**SSD 6011 - Mixed use residential development within the South West Plot**

**Submission by:**

**Mr Don Smythe**

**21 July 2013**

## Winter Solstice (21<sup>st</sup> June)

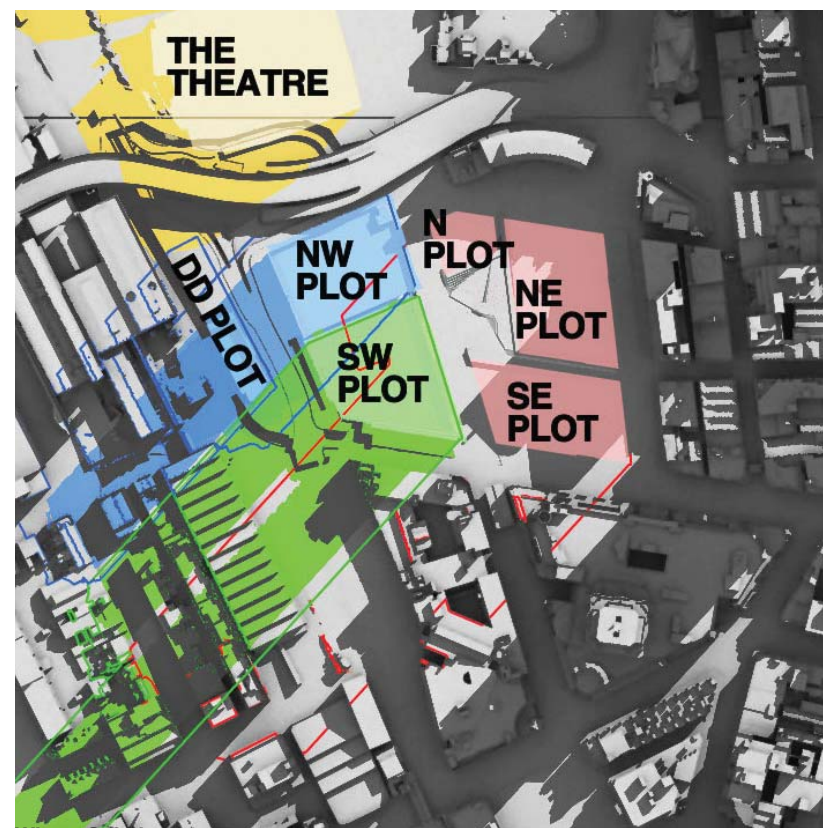
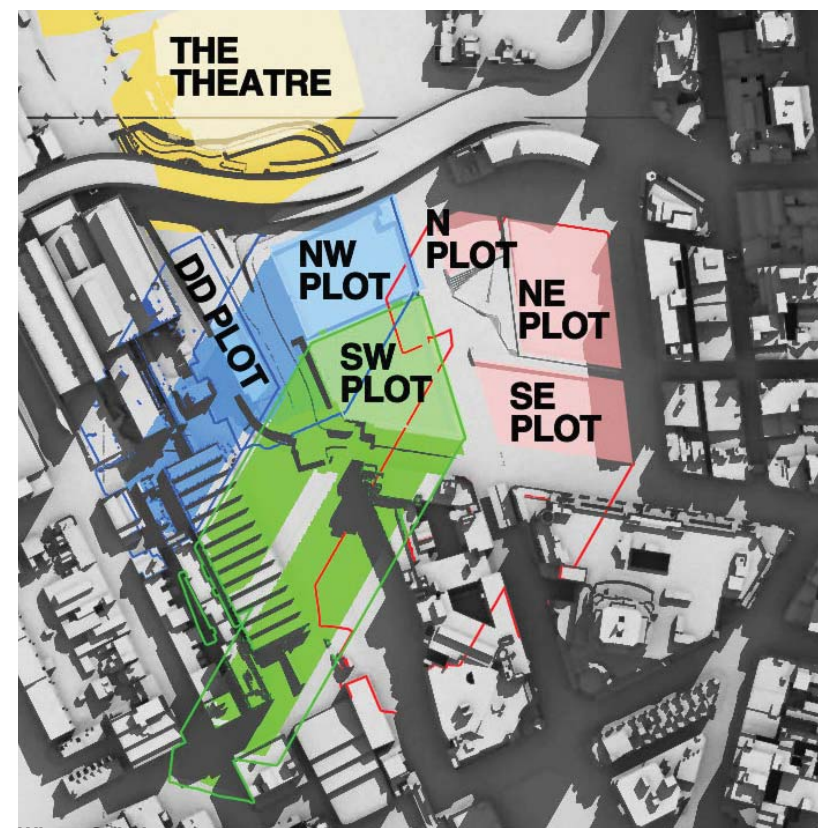
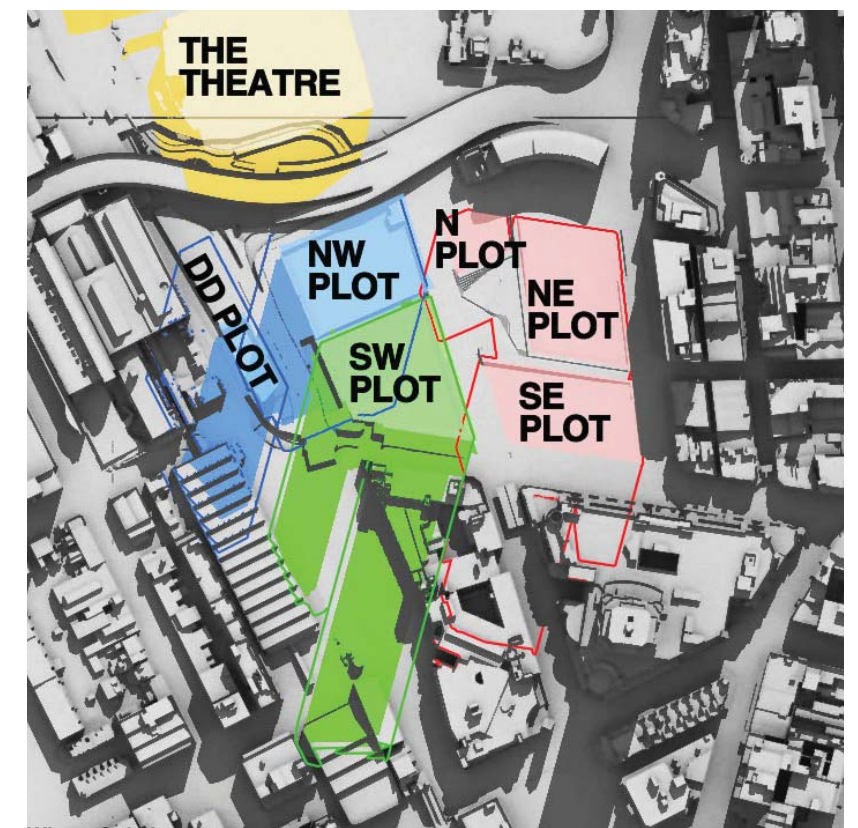
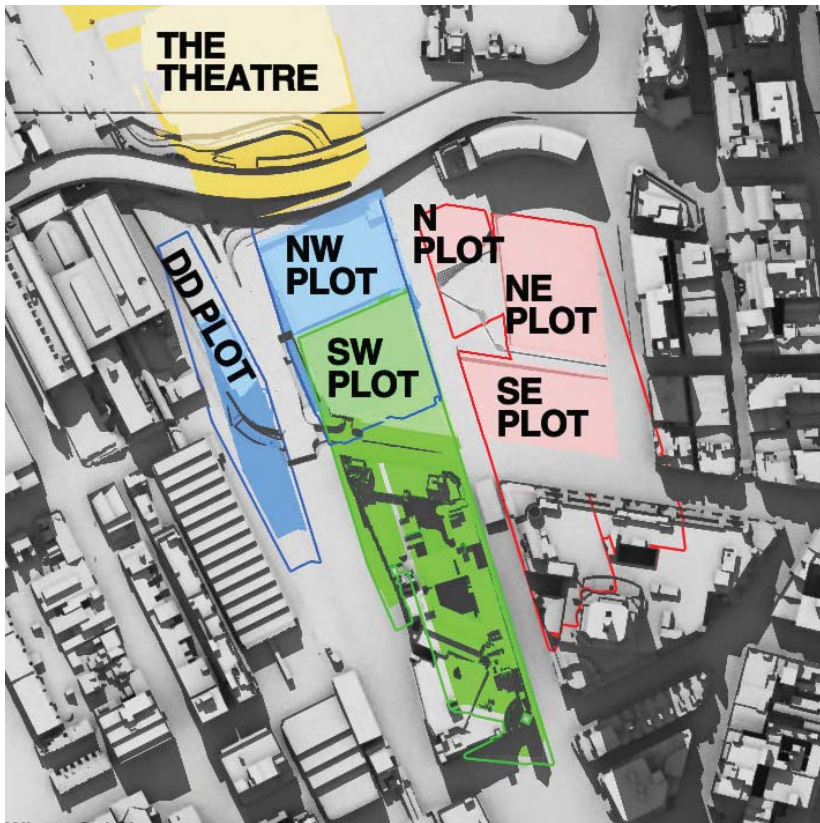
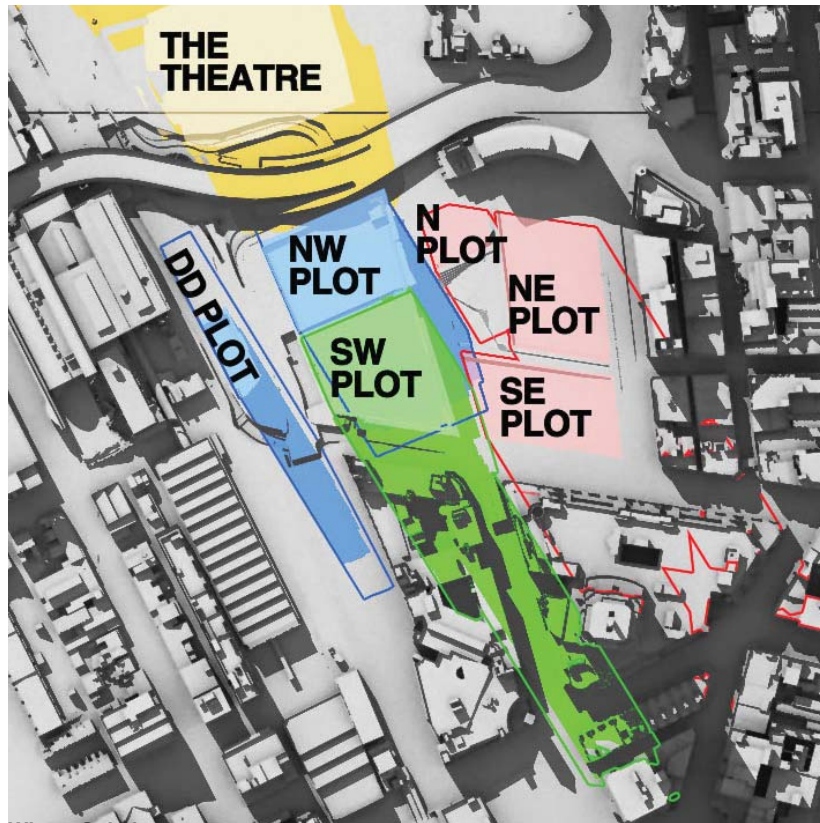
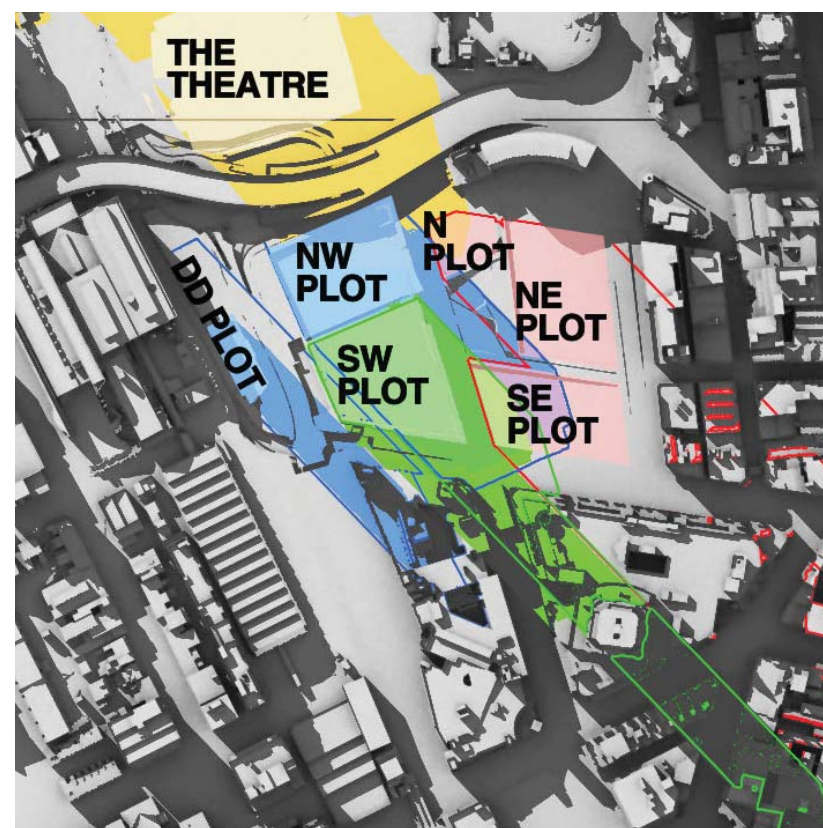
We refer to the shadow diagrams in SSD5878, Appendix H. Supplementary Design Report, Section 6. Amendments, Winter solstice - 22 June. This is not 21 June, but there would be no noticeable difference.

At 9am, 10am and 11am the west façade is totally in shadow due to other parts of The Peak building itself.

At 12pm there is still substantial existing shadowing on the west façade caused by the irregular shape of the west facade.

At 1pm the existing shadowing has been substantially removed, but not totally removed.

It can be concluded that some single aspect apartments on the west façade and some south-west dual aspect corner apartments currently receive less than 2 hours direct sunlight to habitable rooms and 50% of the private open space between 9am and 3pm on 21 June.

By 2pm the existing shadowing has been totally removed, but that is too late to achieve two hours of direct sunlight before 3pm.

At 9am, 10am and 11am the west façade is totally in shadow due to other parts of The Peak building itself.

At 12pm there is still substantial existing shadowing on the west façade caused by the irregular shape of the west facade.

At 1pm the existing shadowing has been substantially, although not entirely, removed. However, overshadowing of lower levels of the west façade by the concept proposal parameter plan shadows for the N,NE and SE plots has already started.

By 2pm the existing shadowing has been totally removed. However, overshadowing of the west façade by the SSDA4 and SSDA5 buildings has appeared and risen further up the west façade than the concept proposal parameter plan shadows for the N,NE and SE plots, which is still present.

At 3pm, the proponent states correctly that 45-45% of the western façade is overshadowed by the SSDA4 and SSDA5 buildings.

It can be concluded that, as a result of combination of the proposed development with existing shadowing of the west façade, some single aspect apartments on the west façade and the south-west dual aspect corner apartments which currently receive less than 2 hours direct sunlight to habitable rooms and 50% of the private open space between 9am and 3pm on 21 June will suffer additional overshadowing. It is beyond our skills to count the number of such apartments. We note that the proponent has made no attempt to do so.

Rather than counting the number of units which will not meet the DCP guidelines, the proponent attempts to trade-off direct sunlight at 4pm for lack of direct sunlight during the period 9am to 3pm. There is no provision in the DCP guidelines for such a trade-off.
